Item No. **Report of the Head of Planning, Building Control, Sport & Green Spaces**

Address 120 HARTLAND DRIVE RUISLIP

Development: Use of dwelling for respite care for disabled children (not more than 6 residents living together as a single household) and conversion of roofspace to habitable use to include a rear dormer, 2 front rooflights and conversion of roof from hip to gable end with new gable end window

LBH Ref Nos: **39206/APP/2014/4117**

Dwg. No. 14160/03 Rev.

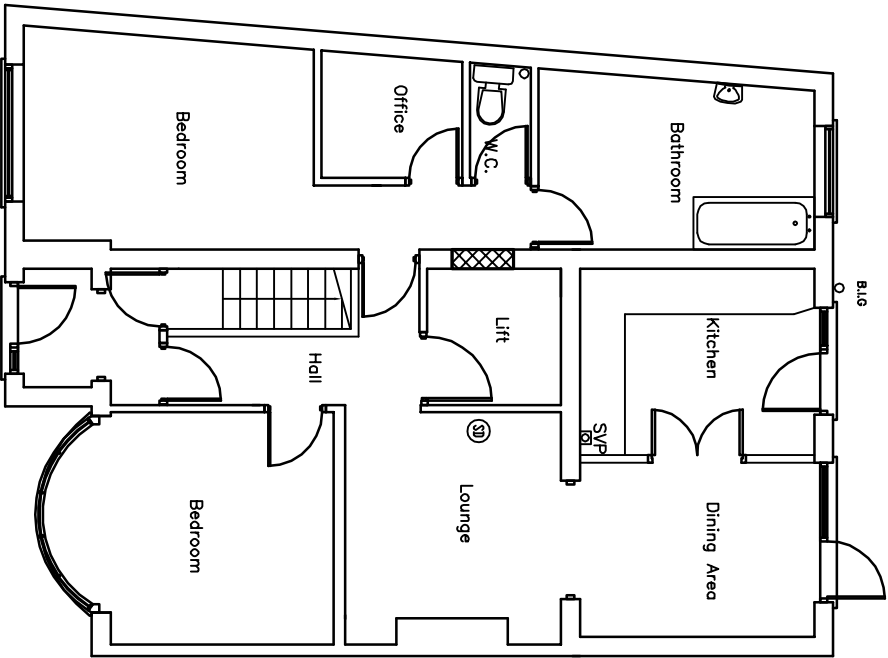
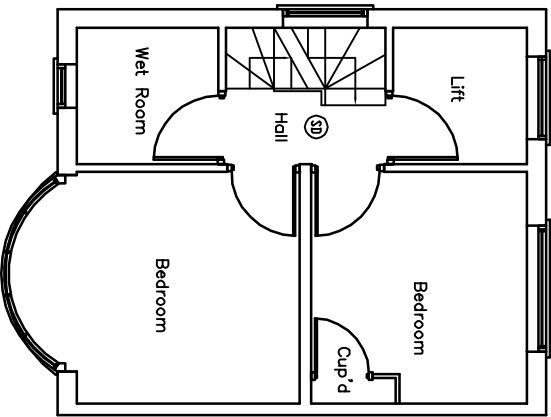
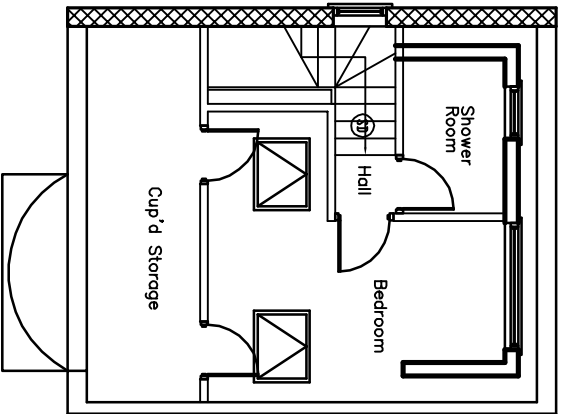
The proposal would provide insufficient parking provision for the proposed residential units and would therefore result in an increase in on-street car parking in an area where parking demand already exceeds supply, thereby leading to conditions which would be prejudicial to the operation of the highway network and pedestrian/highway safety.

The proposal would provide insufficient parking provision for the enlarged residential unit and would therefore result in an increase in on-street car parking in an area where parking demand already exceeds supply, thereby leading to conditions which would be prejudicial to pedestrian and highway safety. The proposal is therefore contrary to Policies AM7 and AM14 of the Hillingdon Local Plan: Part Two - Saved UDP Policies (November 2012) and the Council's adopted Supplementary Planning Document HDAS: Residential Extensions.

Further to reviewing the above, I would comment that the development will remove the existing car parking provision at the site and will not provide car parking for the proposed use. In addition, it is noted that the adjacent highway network suffers a high demand for kerbside parking during both the day and evening times. Furthermore, the applicant has not provided any justification for the non provision of car or cycle parking in relation to the proposals or any information in relation to how the site will operate including the number of staff etc.

The proposal would provide insufficient parking provision for the proposed residential units and would therefore result in an increase in on-street car parking in an area where parking demand already exceeds supply, thereby leading to conditions which would be prejudicial to the operation of the highway network and pedestrian/highway safety. The proposal is

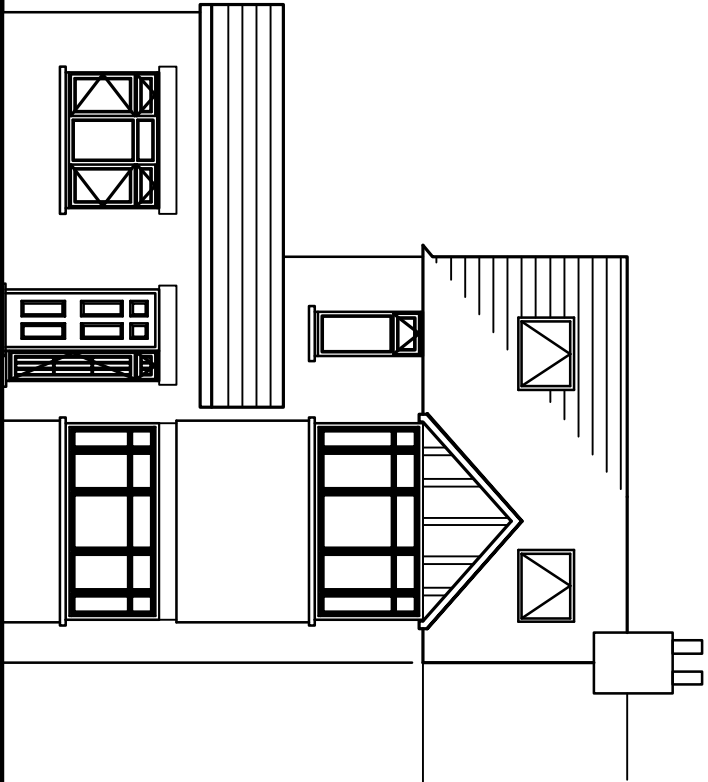
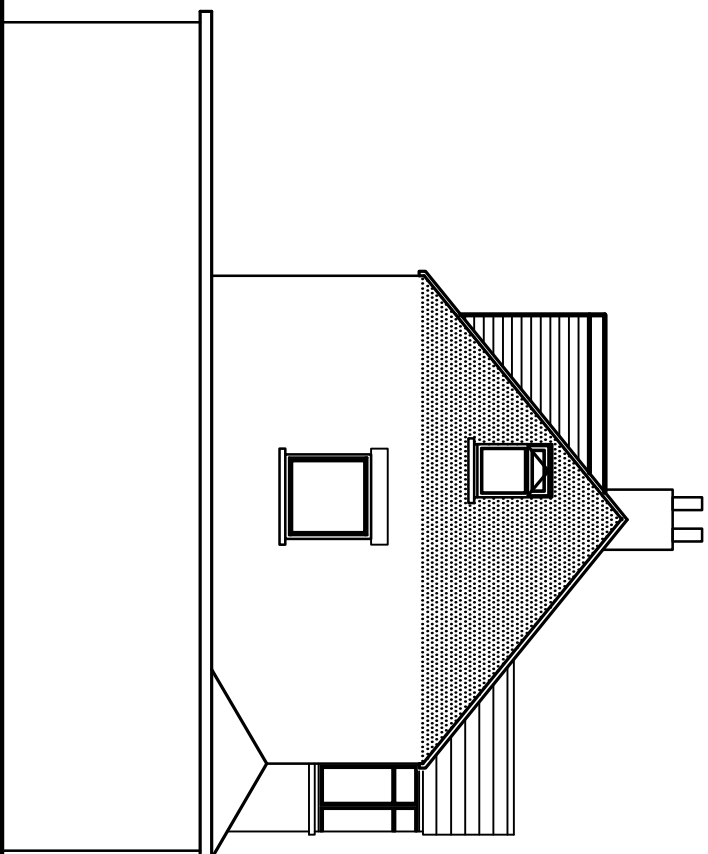
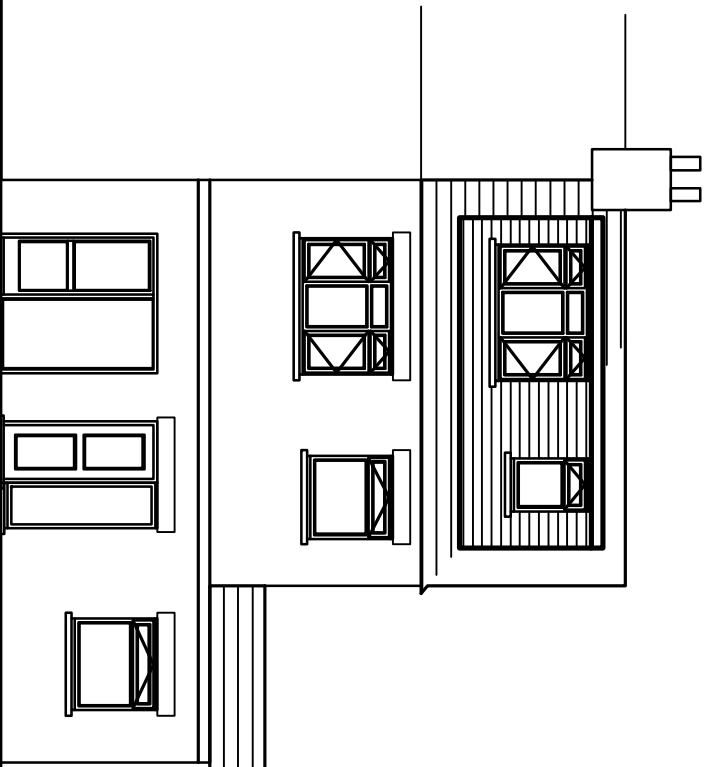
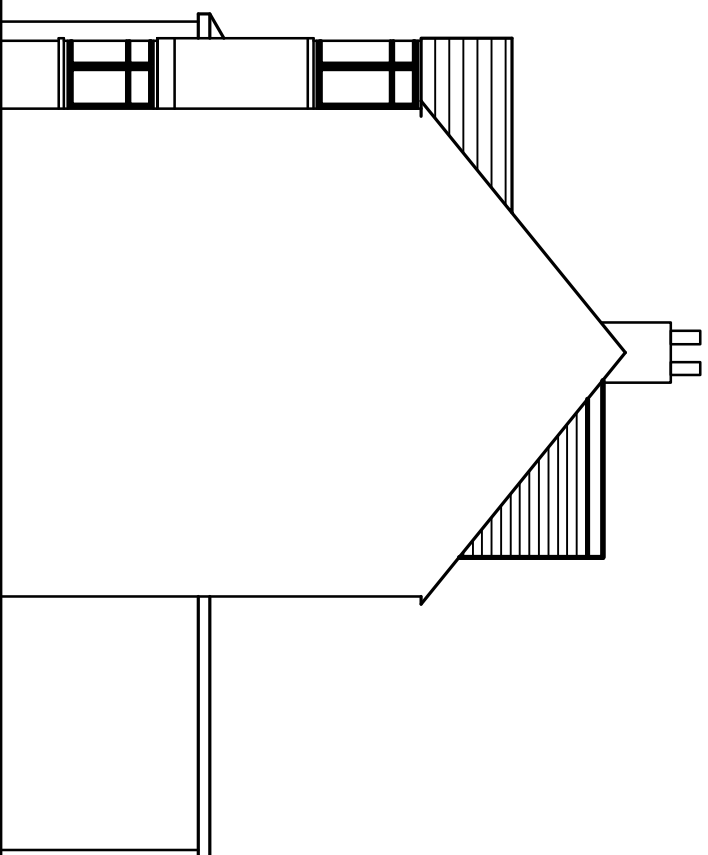
The design and appearance of the proposed hip to gable extension, would contrast with the hipped roof on the other side of the row of terrace. It would appear as a discordant and incongruous addition, detracting from the character and architectural composition of the original house, imparting and asserting an asymmetrical and imbalanced appearance to this row of terraced houses, and as such, would adversely affect the appearance of the street scene and locality.

The roof alteration/extensions, by reason of the hip to gable end roof design and the size, scale, bulk, and design of the rear dormer window, in this visually prominent position, would fail to harmonise with the architectural composition of the original dwelling, would be detrimental to the character, appearance and symmetry of the terrace of houses of

The property is located at a junction in a very visually prominent position. The proposal would result in a hip to gable conversion of the end-of-terrace property and a very large dormer which would dominate the roof space within which it would be set. The dwelling at the other end of the terrace still retains its original hip. Therefore, the hip to gable conversion and the large dormer is considered to have an unacceptable impact on the appearance of the terrace and the visual amenities of the surrounding area. The proposal would therefore be contrary to policy BE1 of the Hillingdon Local Plan: Part One - Strategic Policies (November 2012), policies BE13, BE15 and BE19 of the Hillingdon Local Plan: Part Two - Saved UDP Policies (November 2012) and the adopted Supplementary Planning Document HDAS: Residential Extensions.
